Application Ref:	3/2026/0421			 Ribble Valley Borough Council www.ribblevalley.gov.uk
Date Inspected:	Heritage and Conservation Officer visit on 07/08/2026	Site Notice:	29/07/2026	
Officer:	MC			
DELEGATED ITEM FILE REPORT:				
				APPROVAL

Development Description:	Listed Building Consent for proposed new stair and first floor within a portion of the main hall, insertion of glazing in wall to create viewing gallery and insertion of secondary glazing to three existing windows.
Site Address/Location:	Chipping Congregational Church Garstang Road Chipping PR3 2QH

Glazed viewing screen - validation detail

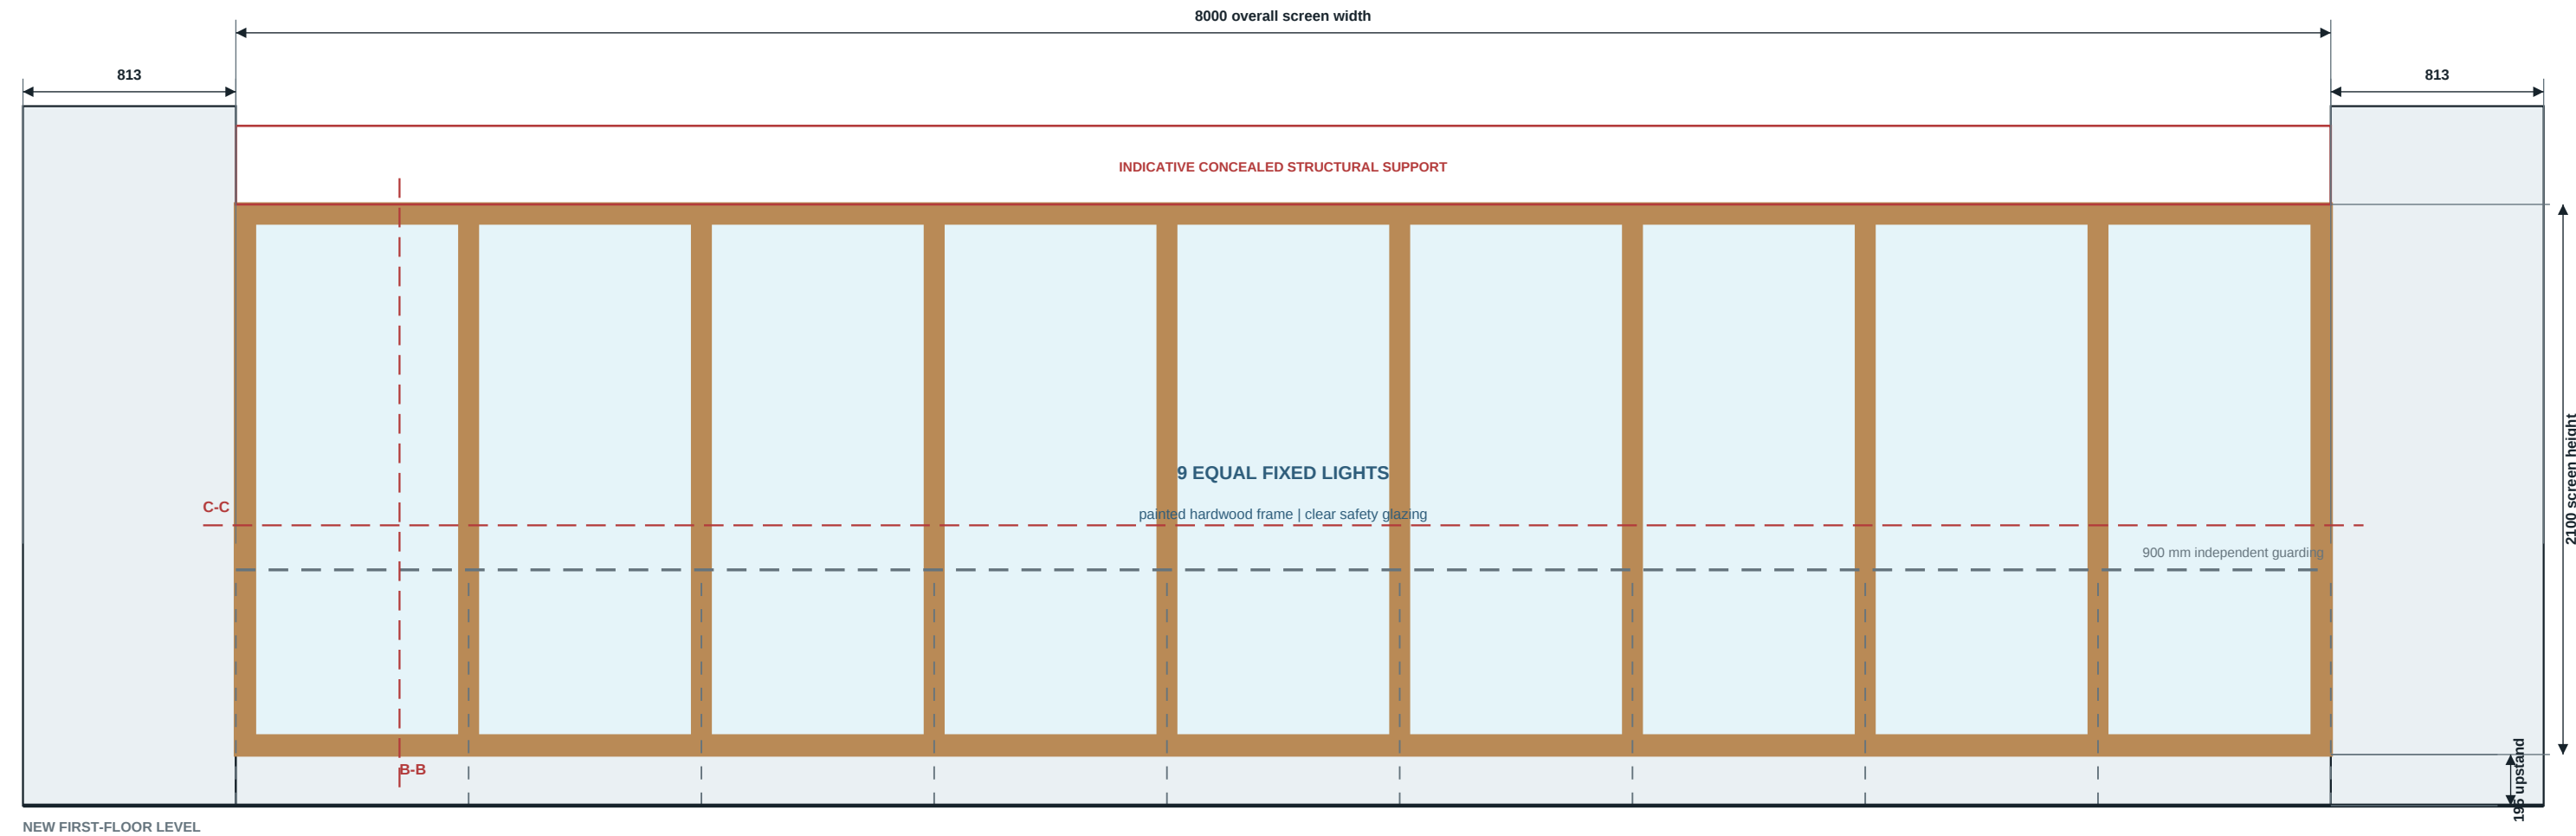
Internally the space is divided by a modern screen at ground floor, though this appears as a lightweight structure with openable doors creating a single space. They note that little historic fabric remains and it has been subject to modernisation. The screen would form the outer wall of the first-floor platform and would have the glazed window.

Whilst there is little fabric remaining, the space remains relatively open and they consider that there would be some low-level harm in dividing the space, as this would obscure its open plan form and block views to the window opposite the door on the east elevation, and reduce the light, open character somewhat. The Heritage and Conservation Officer acknowledges that the window along the frontage of the screen at first floor would provide some, albeit limited, sense of openness, views toward the windows on the east elevation are positive and this would be obscured. These comments are also re-iterated by the Historic Buildings and Places consultee.

Section through B-B

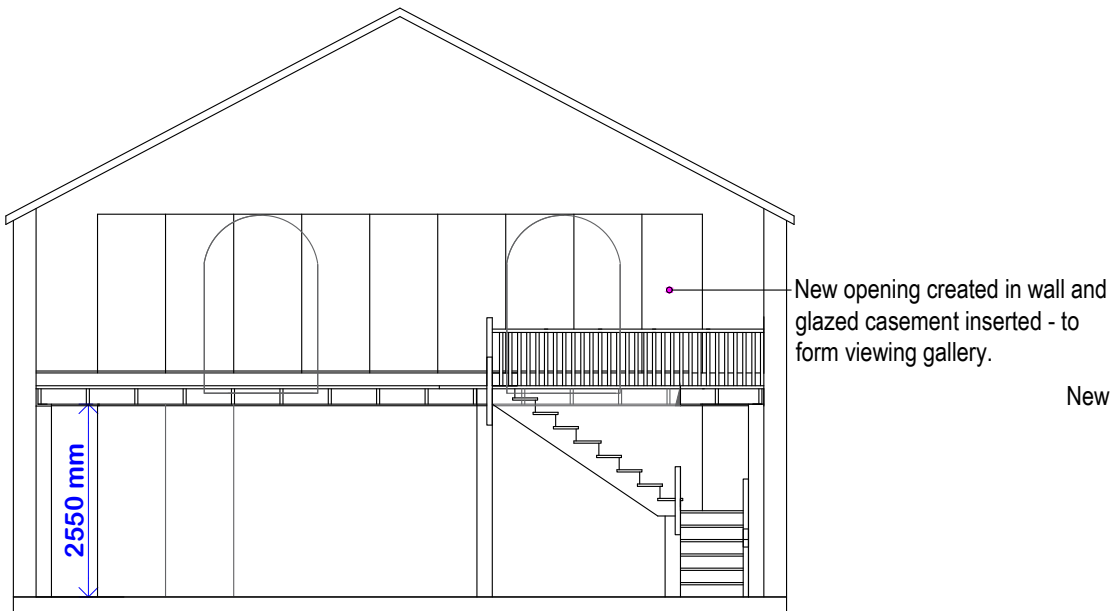
However, the Heritage and Conservation Officer at Growth Lancashire does not think this would amount to any more than negligible harm when viewed externally given the depth of the walling and position of the proposed platform/floor. A section drawing showing the floor levels in relation to the windows can be secured by way of planning condition.
